Planning Ref: PAX16.324258

23 June 2026

Re: PAX16.324258 - The proposed development consists of up to 16 no. wind turbines (Tirawley Wind Farm), including a 110kV sub-station on site, an energy storage system in the form of a battery array located within container units and all associated infrastructure AT the townlands of Ballymurphy, Ballynaleck, Barnhill Lower and others, County Mayo

Plate 12.4: Landscape character units in relation to the Proposed Development in the current Mayo CDP (2022-2028)

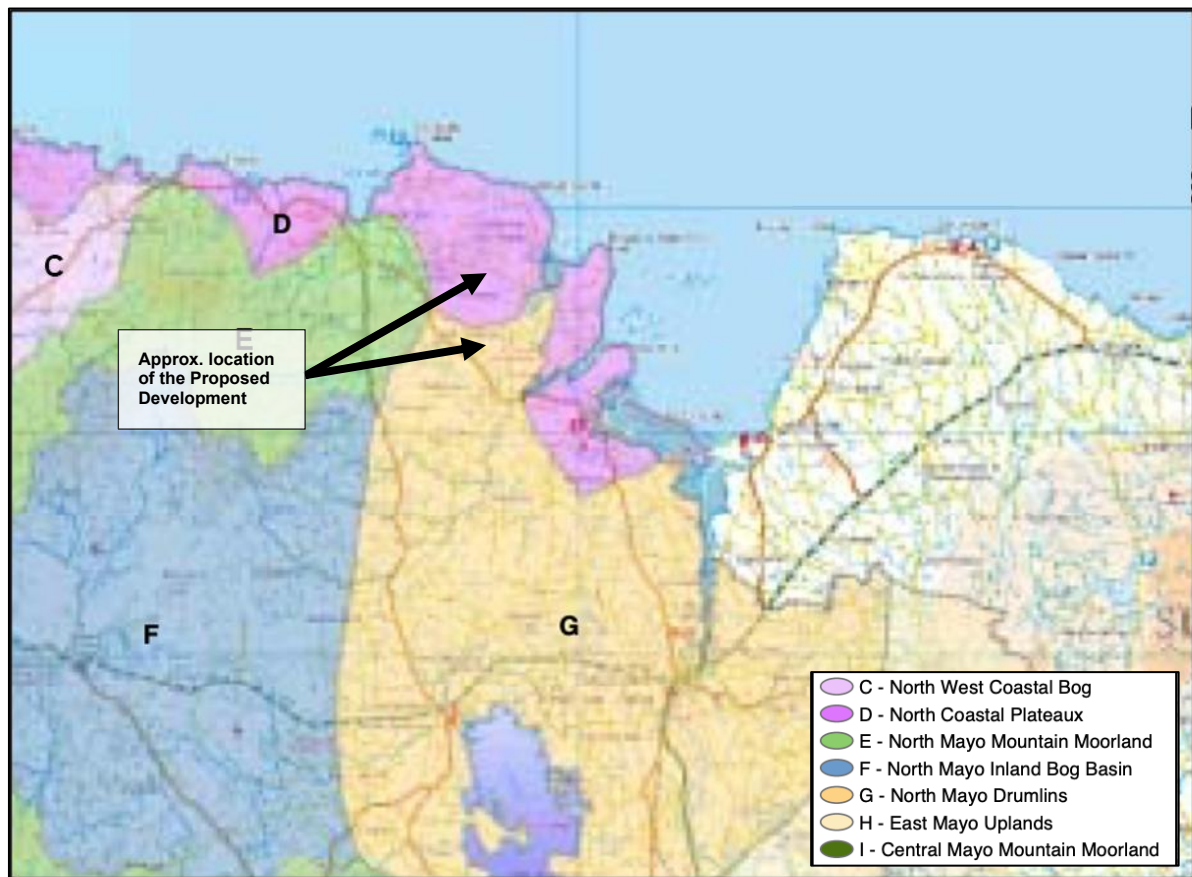
The study area comprises two landscape character units:

- D – North Coast Plateaux
- G – North Mayo Drumlins

In summary we do not agree with the suggestion that the study area is a *medium* sensitivity landscape receptor. It should be segregated by the two landscape units and by association the two policy areas, as per the Landscape Appraisal cited under Policy NEO 27 of the adopted Mayo County Development Plan 2022-2028. Therefore, the premise of the conclusion is somewhat flawed.

Plate 12.5: Excerpt from Map 10.1 showing landscape policy areas in relation to the Proposed Development in the current Mayo CDP (2022-2028)

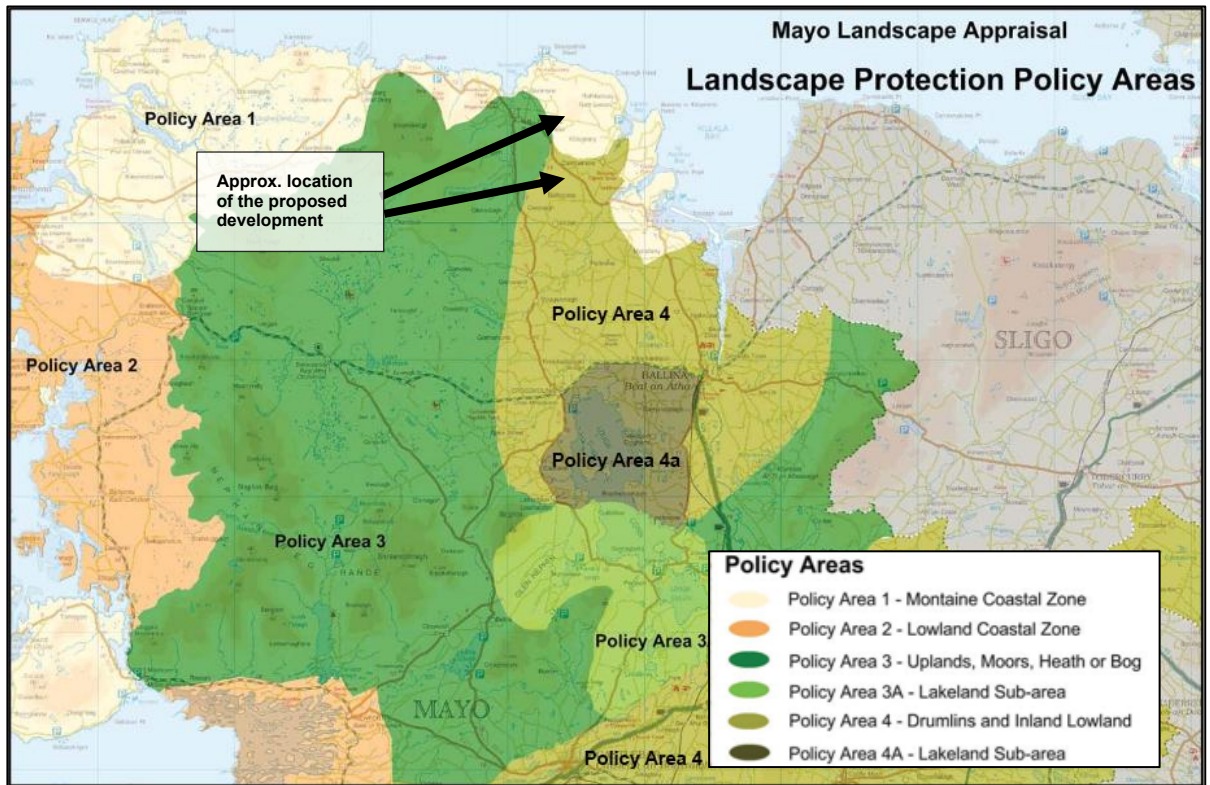
From the outset, we do not agree with the method of assessment in the landscape chapter whereby the sensitivity of the relevant landscapes has been aggregated within a 5km central study area, resulting in an overall *medium* value sensitivity judgement.

The development site straddles both policy areas. Within Policy Area 1 – Wind farm development is considered to have a *“high potential to create adverse impacts on the existing landscape character and having regard to the intrinsic physical and visual characteristics of the landscape area, it is unlikely that such impacts can be reduced to a widely acceptable level”*. Please see matrix in Appendix A. Regarding this matrix, wind farm development within this area is considered to have a high adverse potential impact.

It is unclear why the EIAR has grouped 'Wind Farms, Power Lines and Communication Masts' together on *high to medium* scale of potential impact. To remove ambiguity, it should be stated that the application is for a wind farm development, and it is considered to have a *high* potential of impact within Policy Area 1¹, as per Appendix A.

We recommend to the Commission that it segregate the study area as suggested here. It is likely that once this is done, the area within Policy Area 1 (Montane Coastal Zone) will encounter a more than substantial-moderate negative impact which would be significant in EIA terms. In this regard, the suitability of this northern section of the site needs to be questioned, as there is a concern regarding the consistency of the proposal with Policy NEO 27, and more generally Policy NEP 14, of the adopted Mayo County Development Plan 2022-2028.
